CM/8/22/DOC

Kents Farm House Brookpit Lane Climping BN17 5QU

Approval of details reserved by condition imposed under ref CM/51/20/L relating to Condition No 1 - schedule of materials and finishes to be used for external walls and roofs.

Drawing Title
**WINDOW AND DOOR
DETAILS**

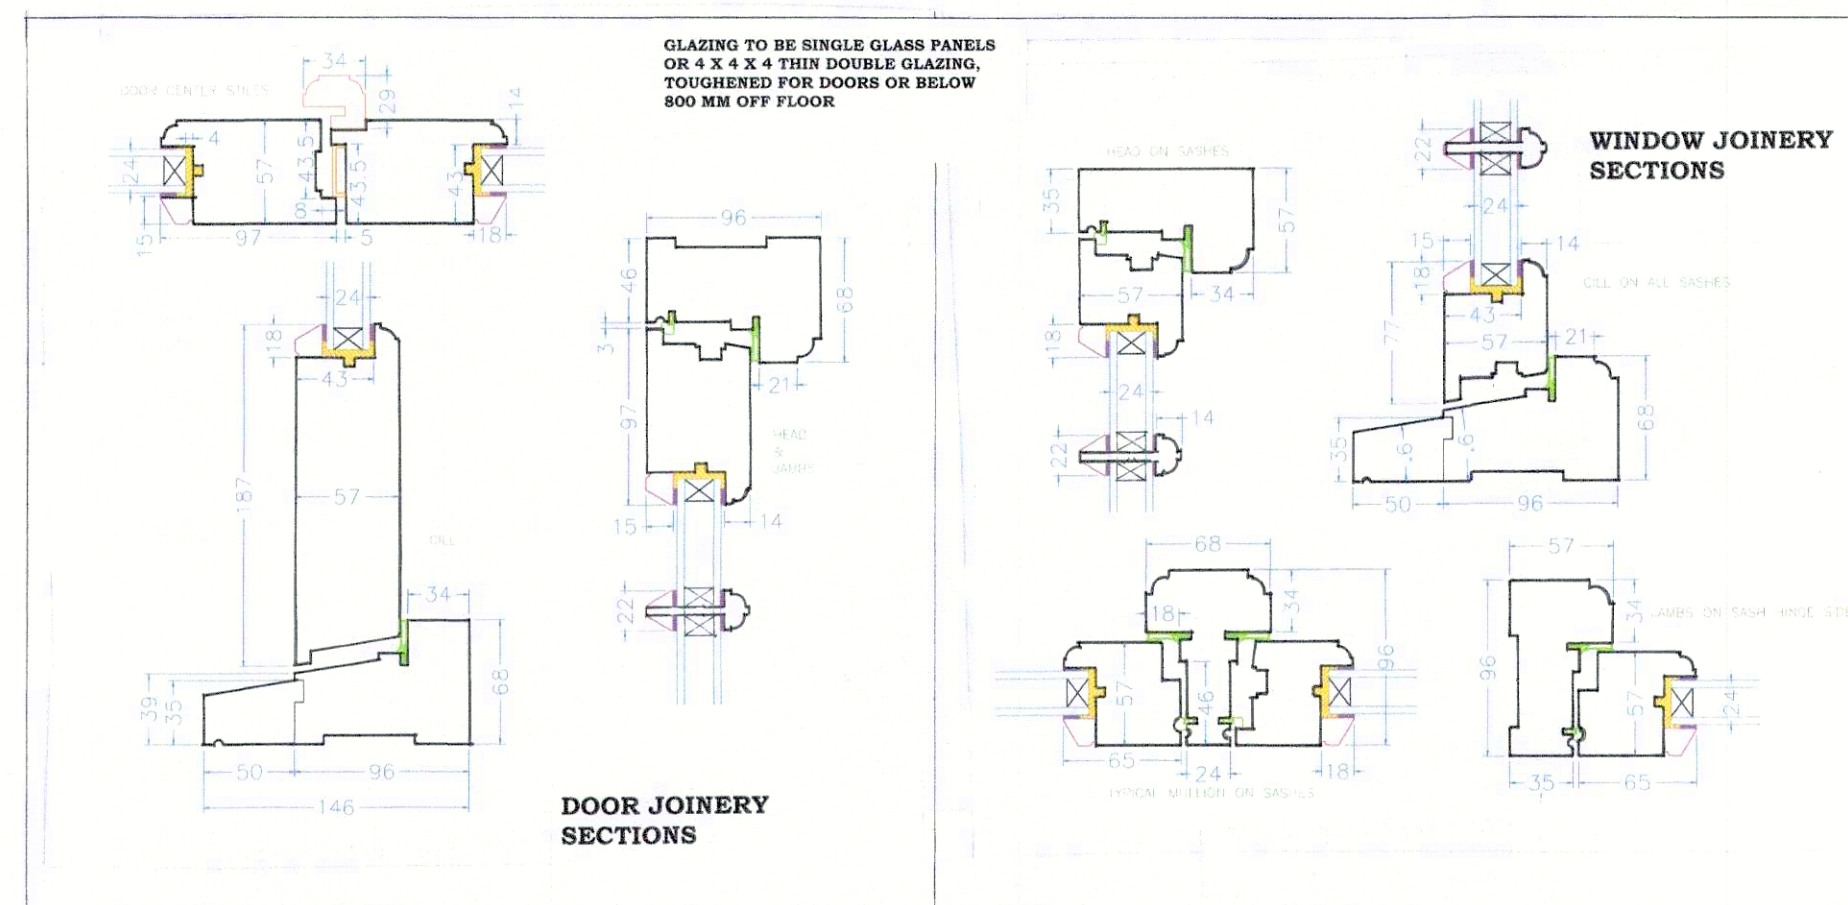
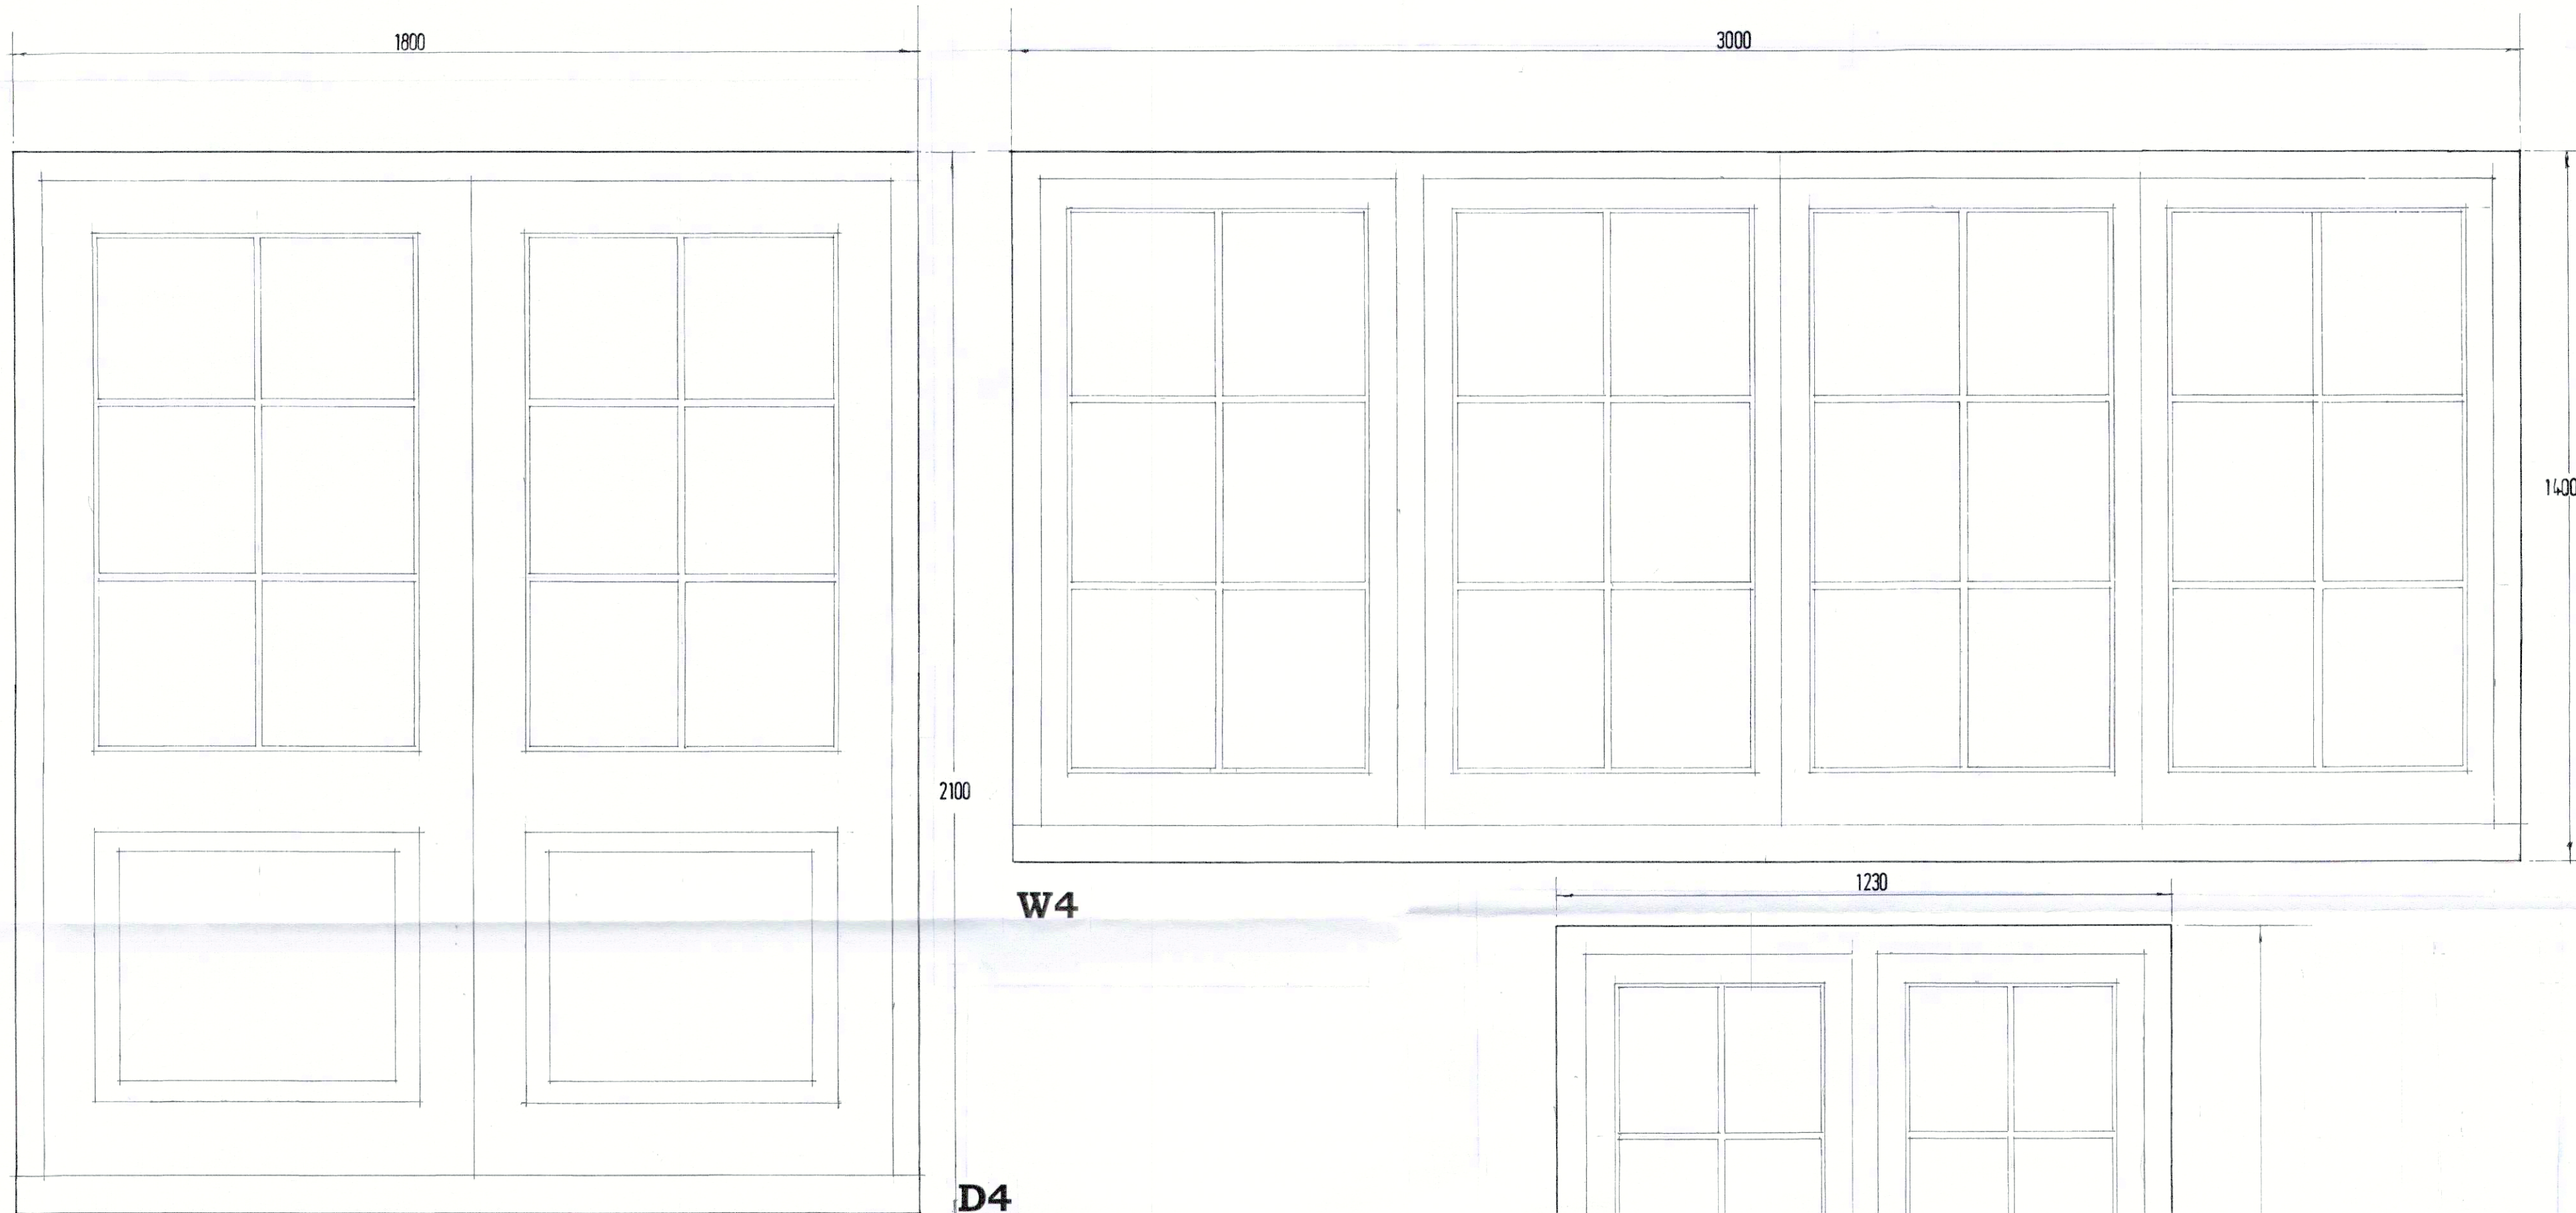
As noted in previous comments on DOC applications, and unfortunately, also noted here as well, the drawings of the windows identify that 'standard' (24mm) double glazed units are to be used for the new/replacement windows. As previously noted, this is not acceptable. If double glazing is to be accepted, it will have to be the slimmer heritage style. However, the cover letter contradicts the plans stating the windows will be single glazed. Please can the glazing be confirmed!
